Recommendation Report for Planning Permission

REF NO: BR/140/14/PL

LOCATION: 12 Chichester Road
Bognor Regis

PROPOSAL: Conversion of existing vacant listed building to provide 4No. flats. Demolition of single storey building at rear (north) and construction of single storey extension and separate 2 storey building to provide 5No. flats. This application affects the setting of a Listed Building. Resubmission following BR/41/14.

DRAWING TITLE
PROPOSED FIRST FLOOR PLAN

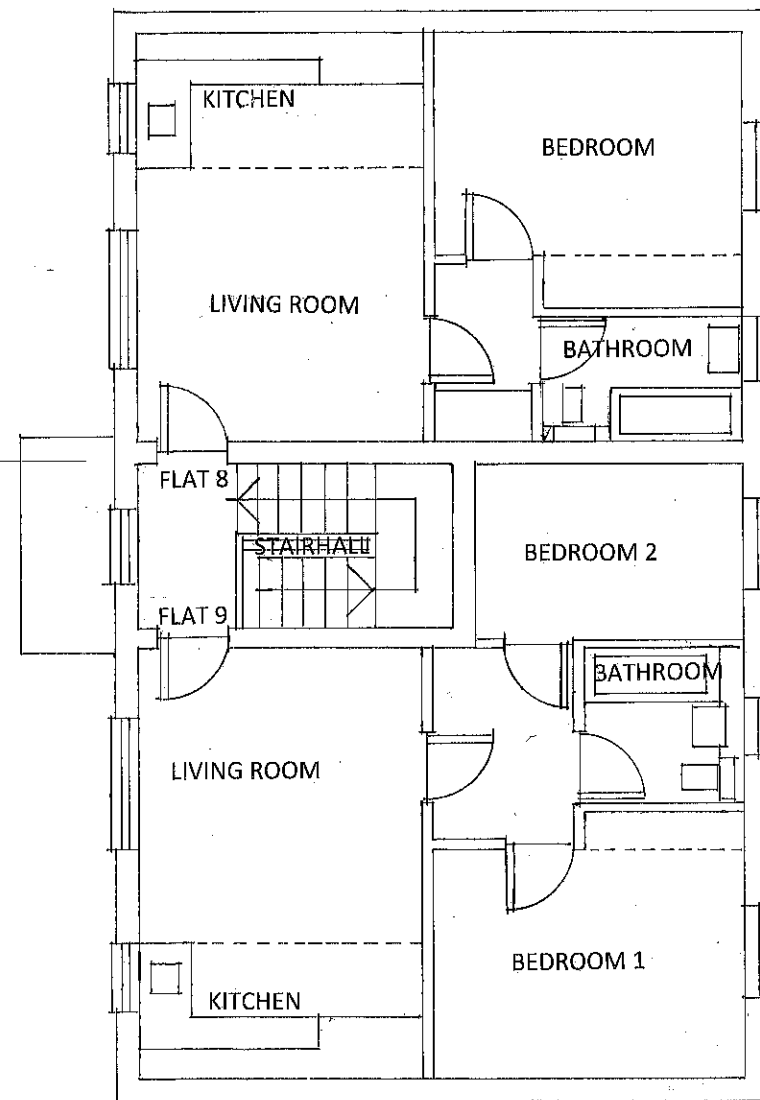
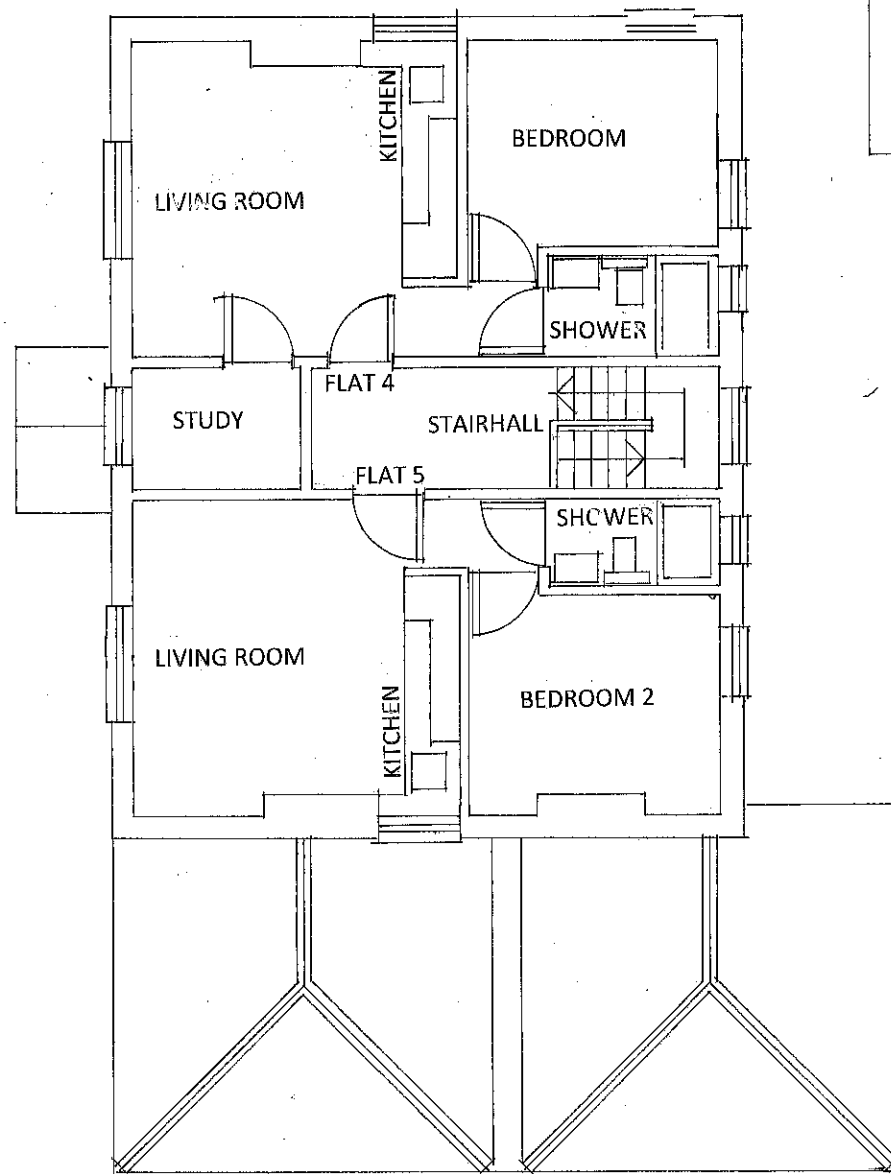
Policy DM2 of the publication version of the Local Plan sets minimum internal space standards for residential dwellings. The new build flats, flats 6-9, meet the minimum space standards as set out within that policy, however the units within the converted listed building do not meet the minimum standards required.

Whilst the minimum internal space standards are not met for flats 1-5, given that they are within the listed building which restricts the form of conversion to some extent, together with the fact that the conversion will ensure that long term retention of the listed building, under provision on room sizes are accepted in this case.

Policy DM3 of the publication version of the Local Plan sets minimal external space standards for residential dwellings. This only sets minimum standards for flats which have 2 bedrooms or more, in the case of 2 bed flats, 5 square metres of private amenity space should be provided. The development largely consists of 1 bedroom flats, with the exception of flats 7 and 9. Whilst sufficient private outdoor amenity space has not been identified, given the area provided as

- 8 Plots 7 and 9 shall not be occupied until a minimum of 5 square metres of private outdoor amenity space has been provided on-site in accordance with detail to be submitted to and approved by the Local Planning Authority. The private amenity spaces shall thereafter be retained for the sole use of plots 7 and 9.

DRAWING TITLE
PROPOSED ELEVATIONS SHEET 2

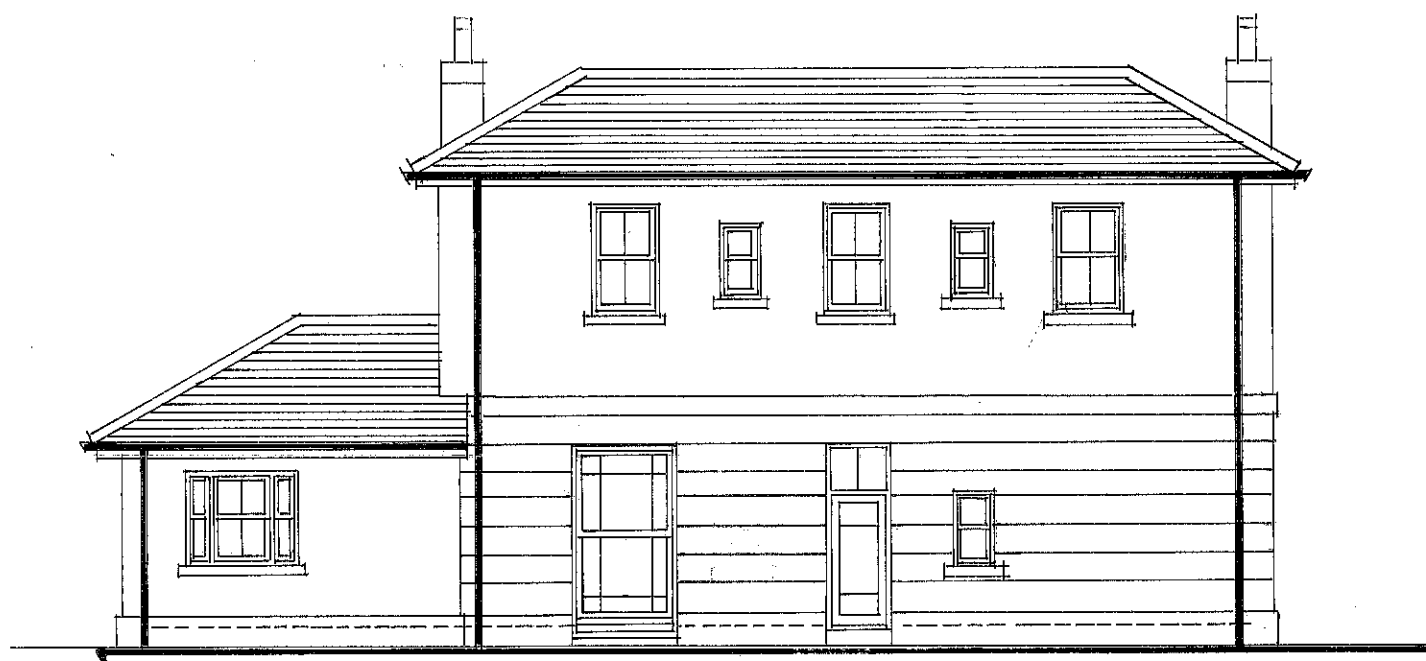
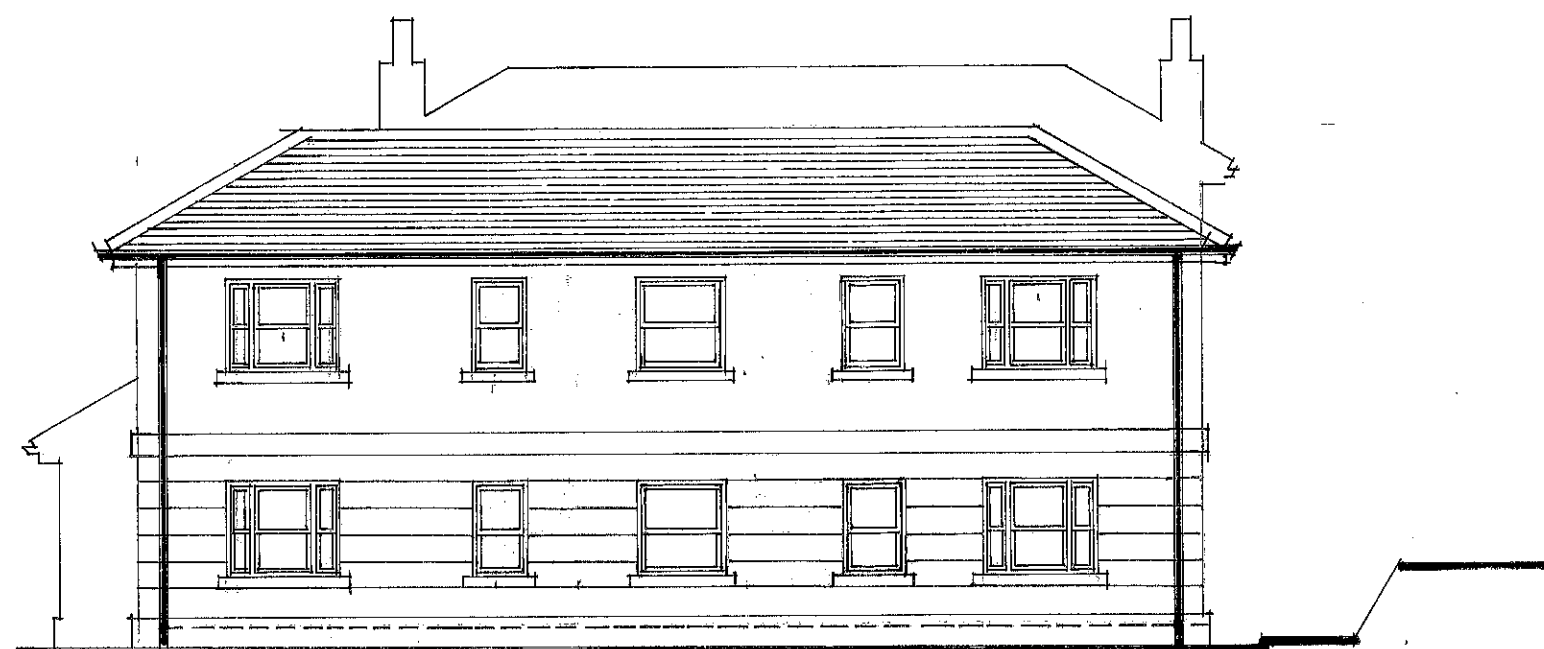
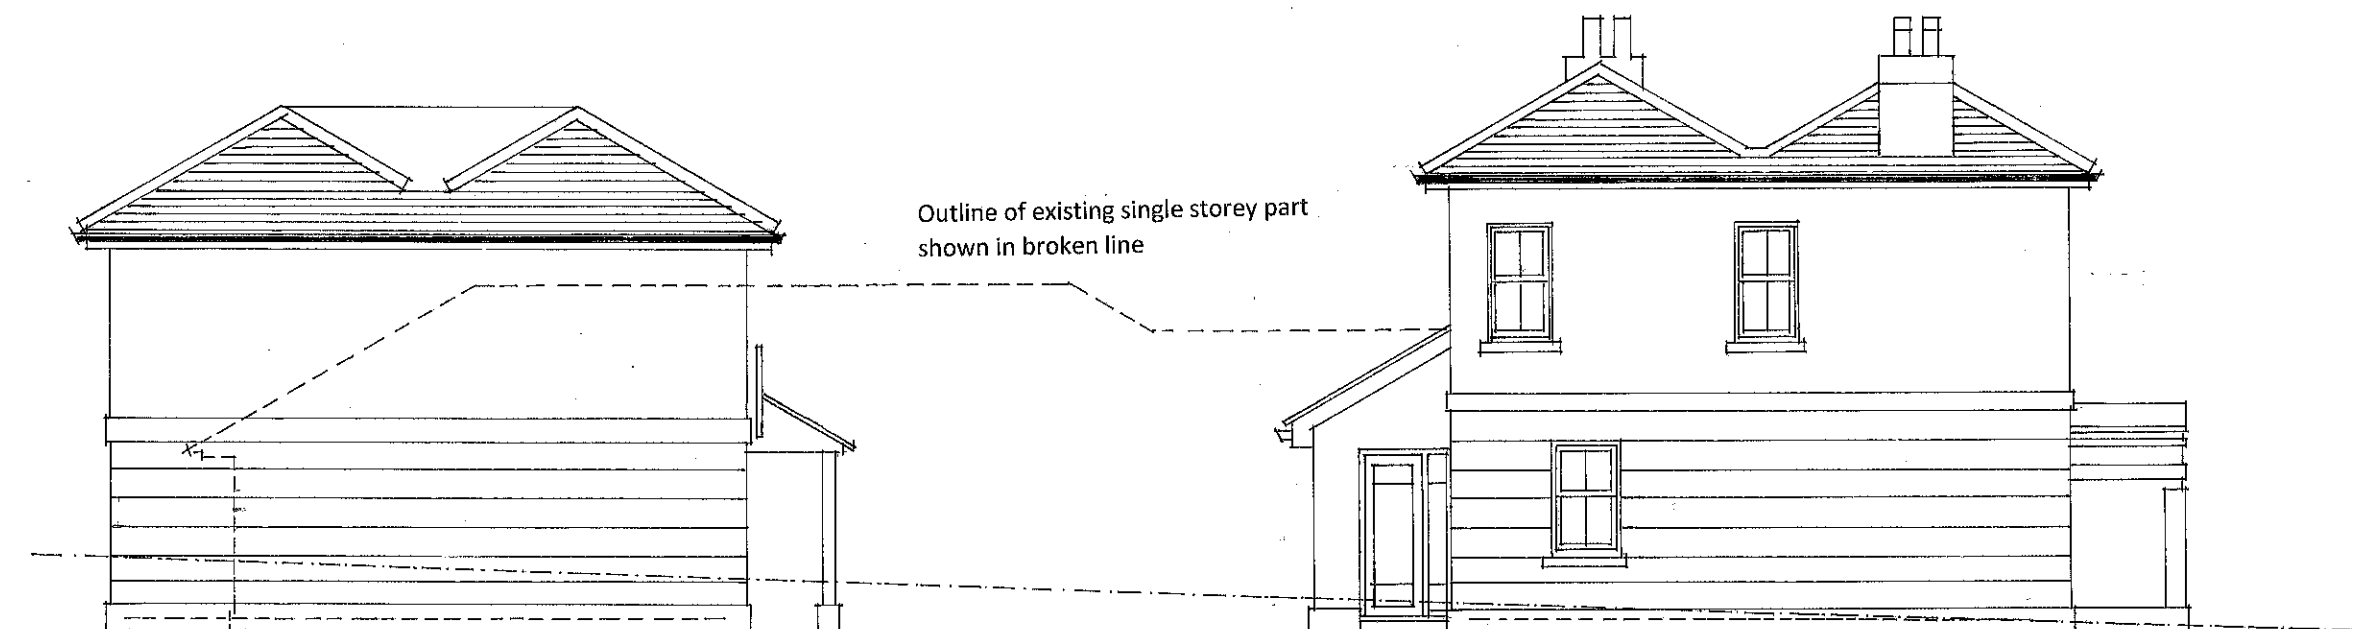
The scheme now proposed ensures that the setting of the building is preserved with the introduction of a detached 2 storey building to the rear of the listed building. Its design, particularly its roof scape is one that compliments the existing building together with the siting.

The internal layout of the existing building has been significantly altered in the past, however its historic layout is still retained in part with the layout proposed, therefore no unacceptable harm results on the historic integrity of the building. The external appearance of the building is to be restored, with existing openings to the front and side elevations retained. A positive of the conversion is the removal of a single storey element on the rear elevation of the building. Its removal allows the rear elevation to be exposed and the rear elevation restored to its former condition.
